Yorkshire Water Services
Developer Services
Pre-Development Team
PO BOX 52
Bradford
BD3 7AY

Your Ref: 2022/92406
Our Ref: Y011528

18th August 2022

Land Adj 67 Chapelgate, Scholes, Holmfirth - Erection of 10 affordable dwellings, with access from Chapelgate and associated works, including resident play zone

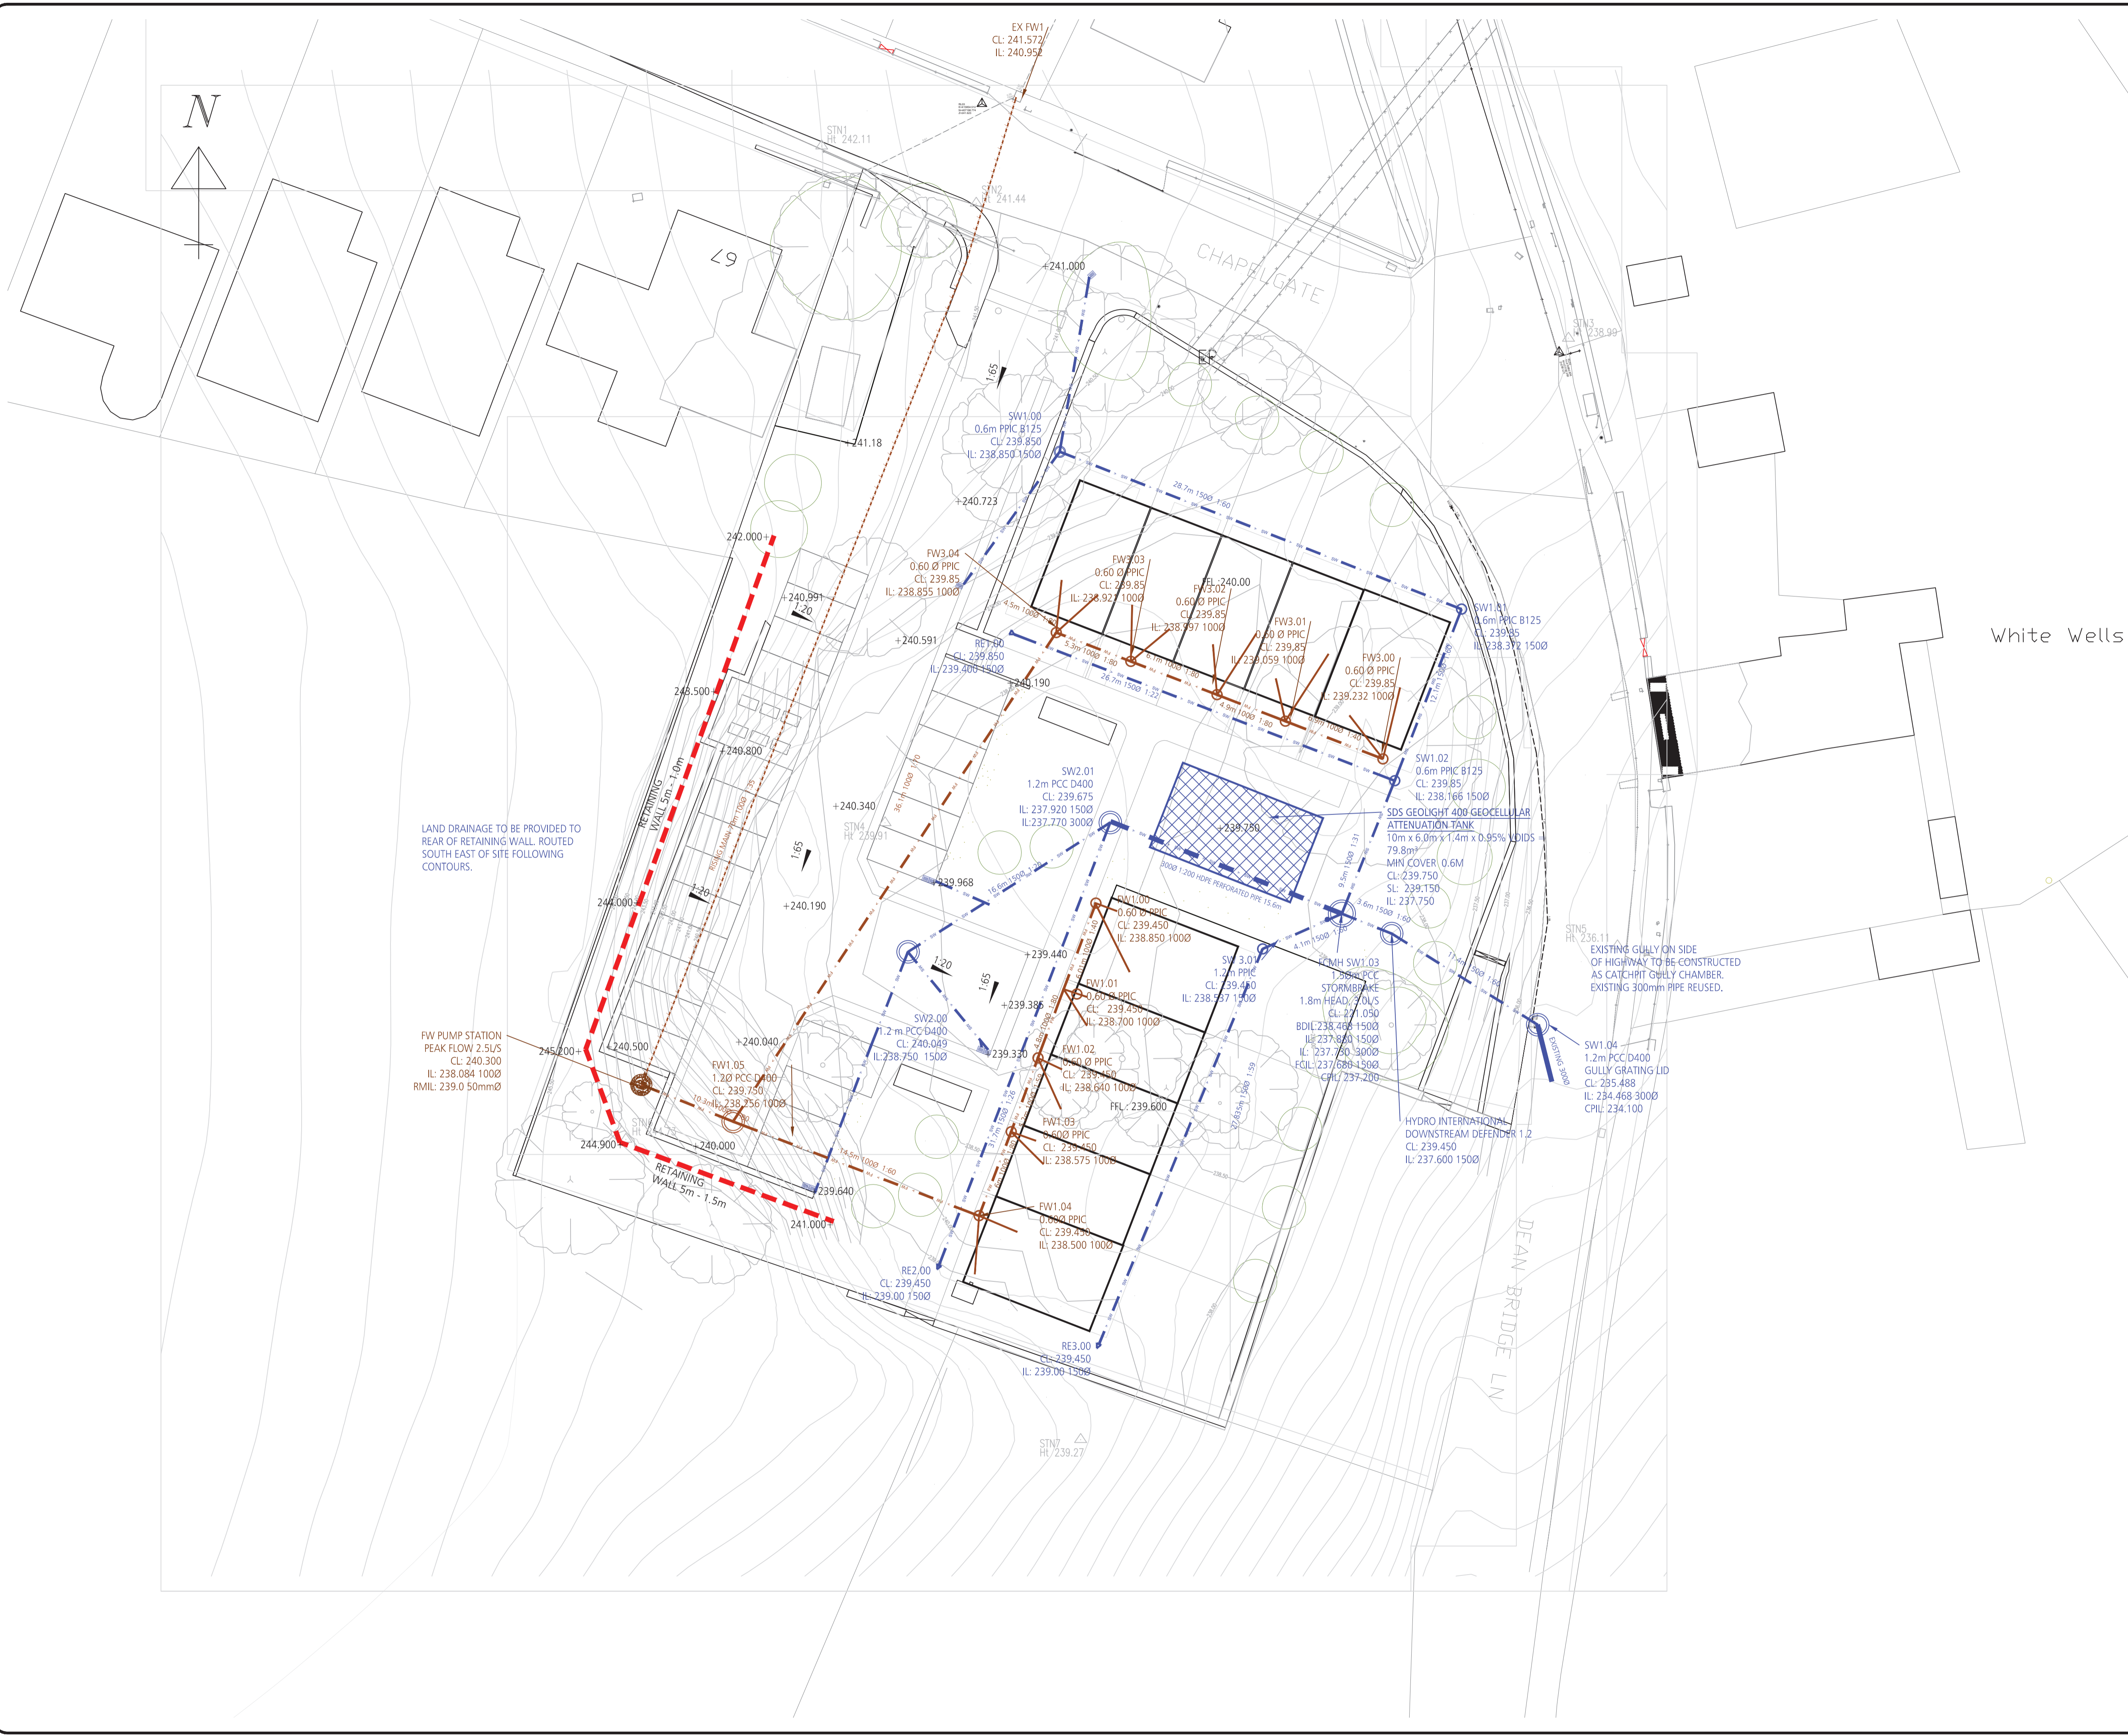
1) It is noted from the submitted planning application that surface water is proposed to be drained to watercourse, via an existing highway drain located just outside of the eastern site boundary. We fully endorse this proposal.

2) The foul water proposals are acceptable in principle. The submitted 'Drainage Strategy' 100 revision P1, dated 07/04/2022 indicates that foul water from the site will discharge via a pumped connection (of 2.5 (two point five litres) per second) to a foul sewer to the north of the site, within the pavement.

The site shall be developed with separate systems of drainage for foul and surface water on and off site. The separate systems should extend to the points of discharge to be agreed. The maximum foul water pump rate shall be restricted to 2.5 (two point five) litres per second. (In the interest of satisfactory and sustainable drainage)
